**SUBMISSION - SSI 9737
SYDNEY GATEWAY ROAD PROJECT**

Re: Sydney Gateway EIS Submission

Table 2.1 **Key items to be addressed by the proponent**

Figure 13.1 Contamination assessment areas

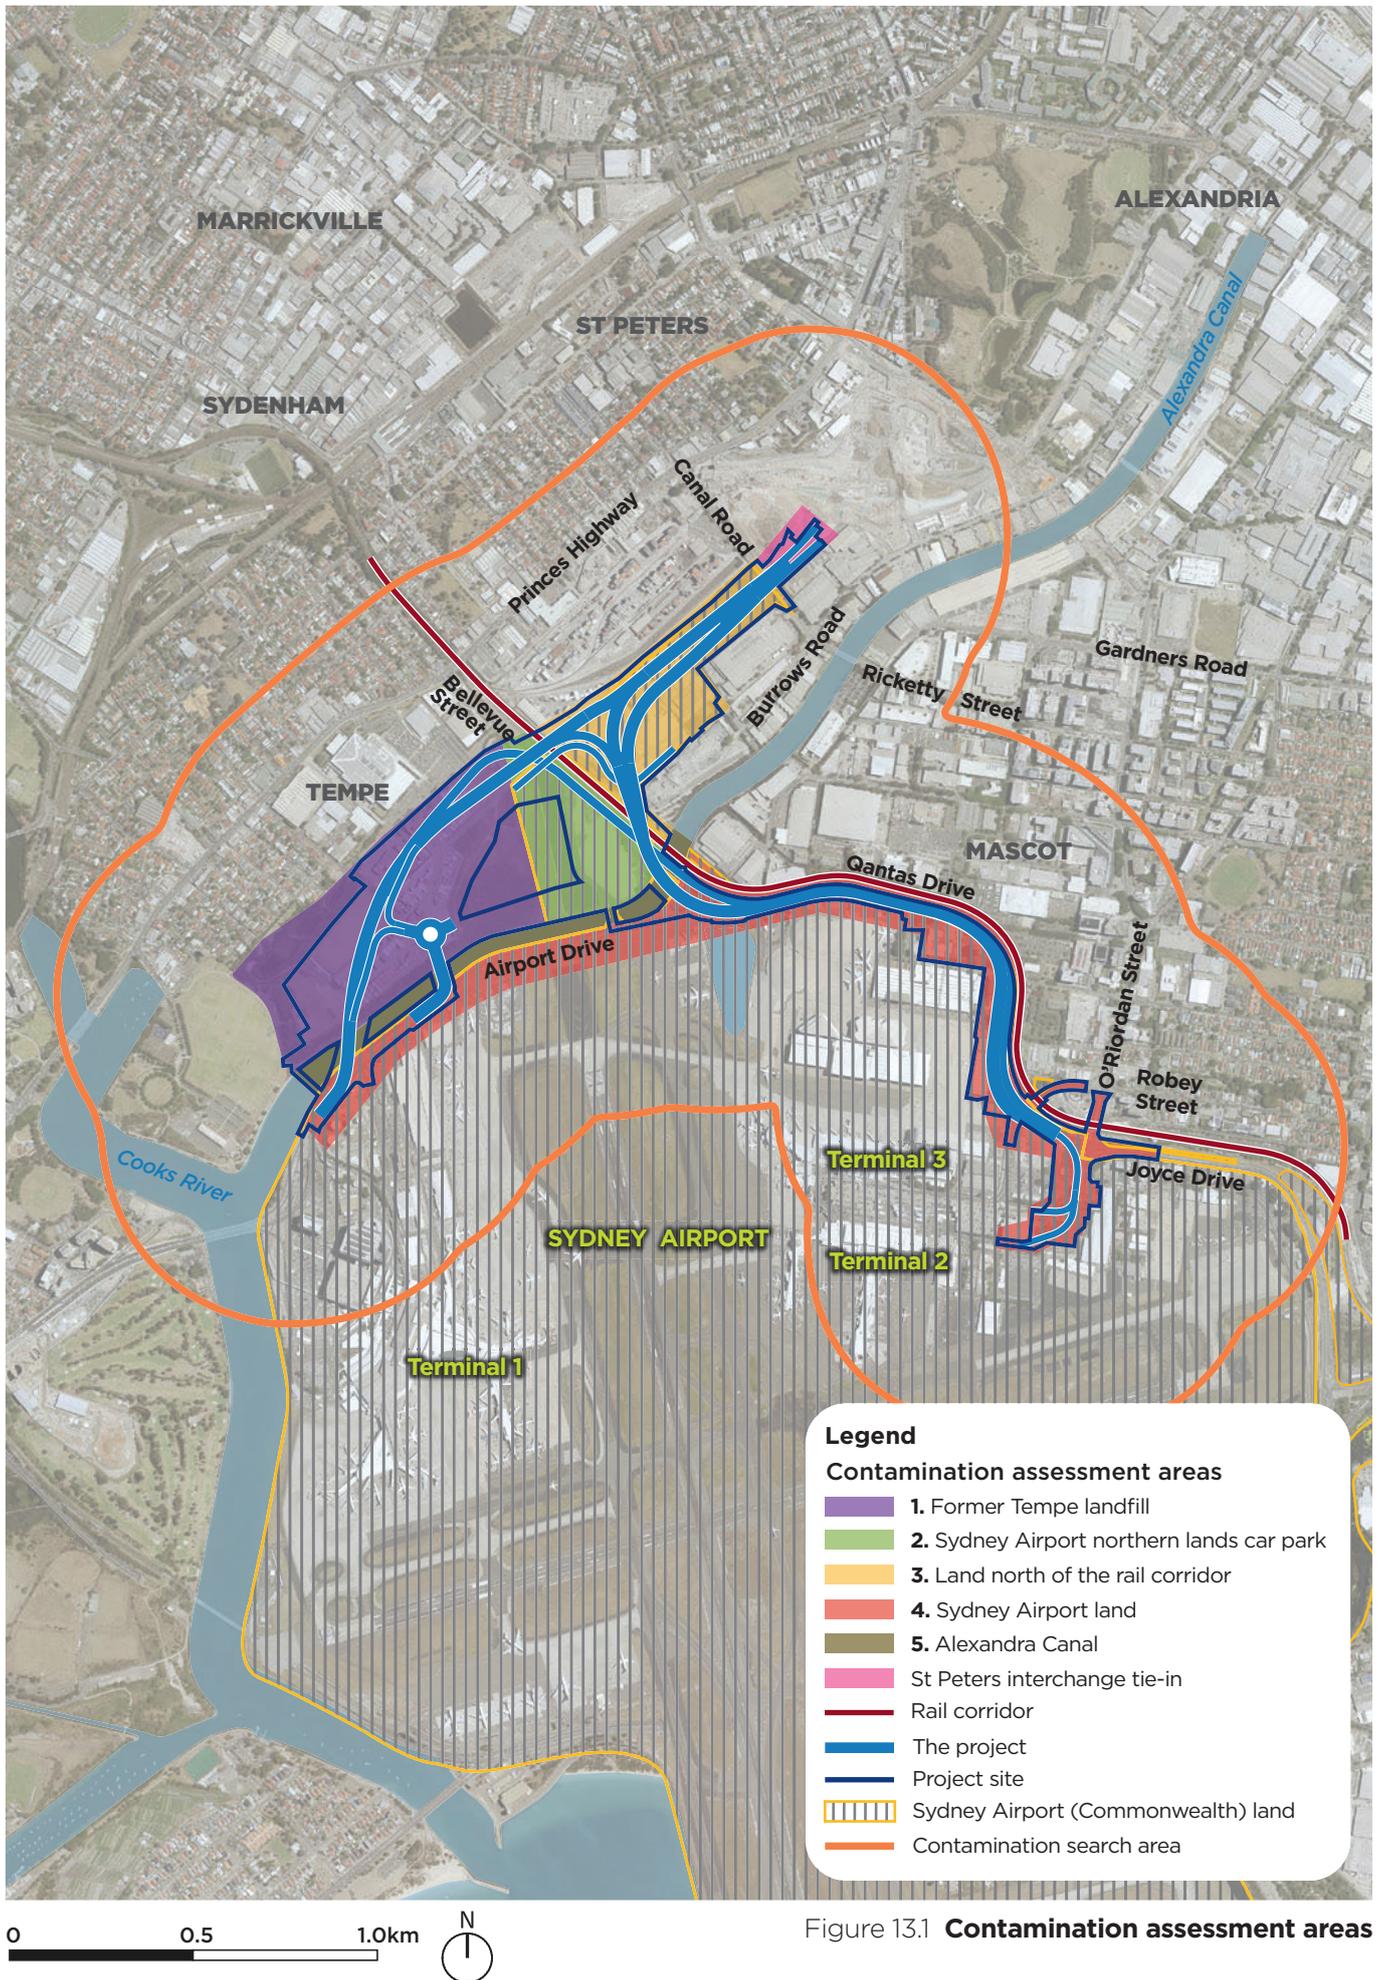
Technical area	Ref no.	Issue of concern	Proposed recommendations
	2.2	Further investigation to characterise contamination within AA3 may identify contamination that is likely to also affect the Boral site (for example, the potential presence of free tar). Investigation and remediation work on AA3 is not in themselves considered likely to impact on the operational capabilities of the Boral site, subject to appropriate management. However, it may trigger a requirement for Boral to undertake investigations and/or remediation within the Boral site, with the potential to impact on operations and/or production.	Boral seeks input to the planning and management of proposed investigations (and potential remediation) within AA3.

2.6	Assurances that the management plans to be prepared for works on AA3 include adequate measures proposed for the safety of workers on the Boral site.	Boral seeks the opportunity to review and provide input to the management plans prepared for works on AA3, to ensure it is satisfied that the measures proposed are adequately protective of workers on the Boral site.
